**Planning Consultation
Response from the Conservation Officer**

Application Number	A/46/14/HH
Address	Woodford Villas 2 High Street Angmering BN16 4AE
Description	Retention of infill Brickwork to front boundary wall. This application affects the character and appearance of Angmering Conservation Area
Case Officer	Mr. P.
Site Visit	15/05/2014

DRAWING TITLE
NEW FRONT BOUNDARY WALL
ELEVATIONS, PLAN AND SECTION

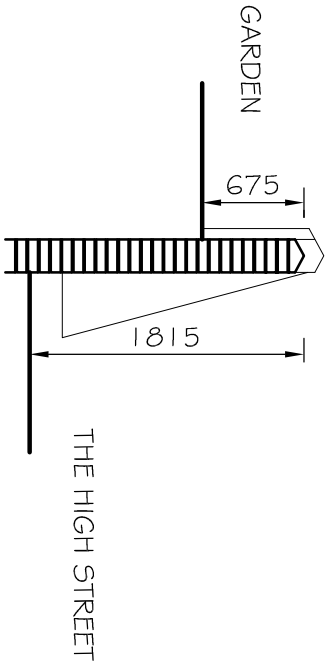
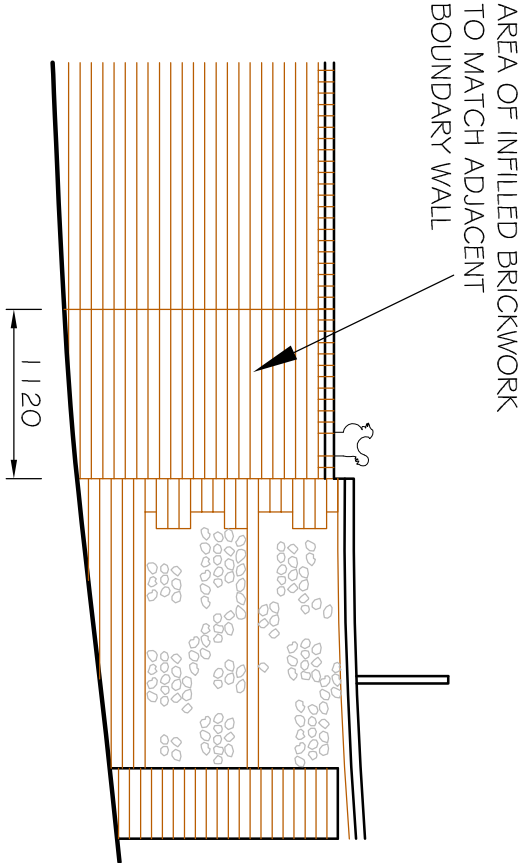
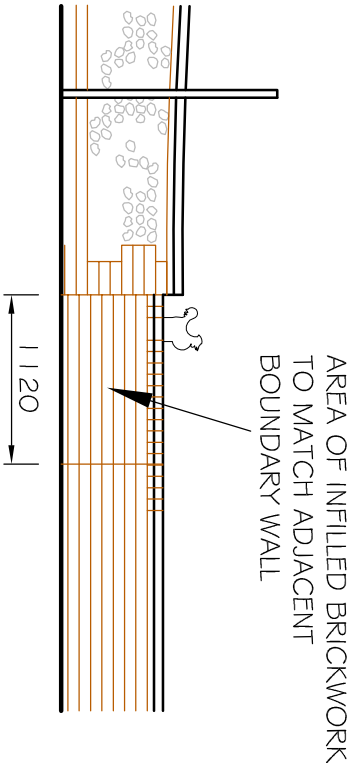
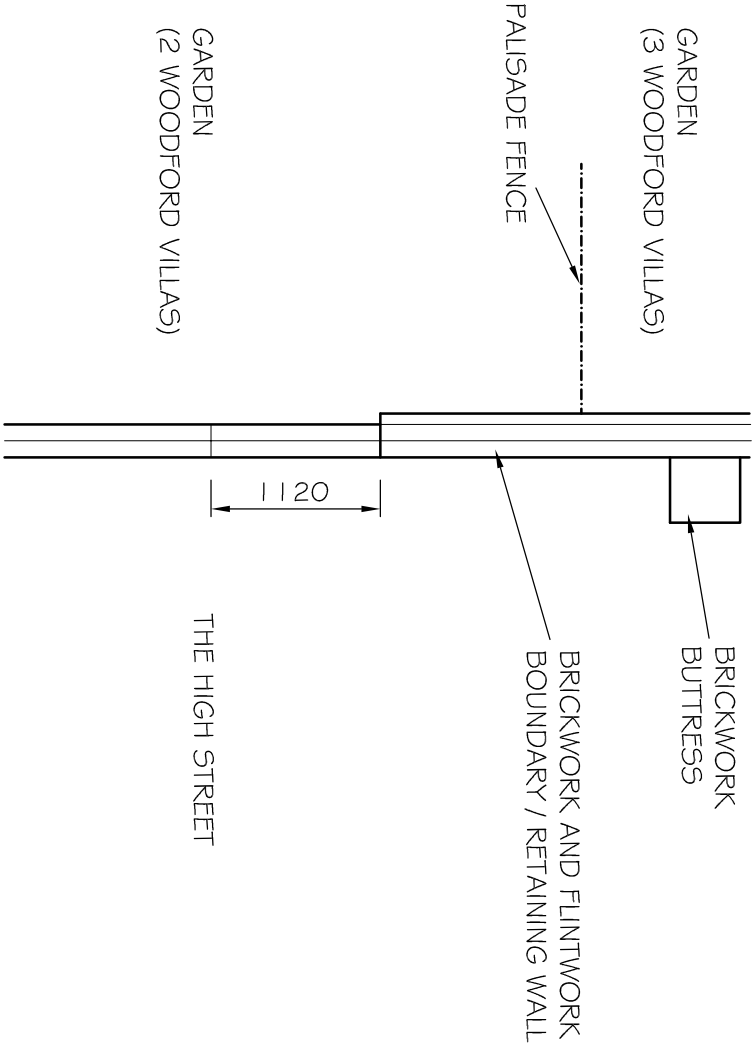
However, as the opening has been in-filled with brick, the quality of the works should have been of a very high quality. Unfortunately, the new section of walling fails to link in to the existing walling and appears almost as if an afterthought. This is evidenced by the distinctive joints between the existing and new sections of walling, and is unfortunate.

It is a shame that the opening had to be permanently in-filled as it is not known if this was a historic access point. An alternative approach would have been to close the opening with a gate or similar to enable the views through to the space beyond to remain.
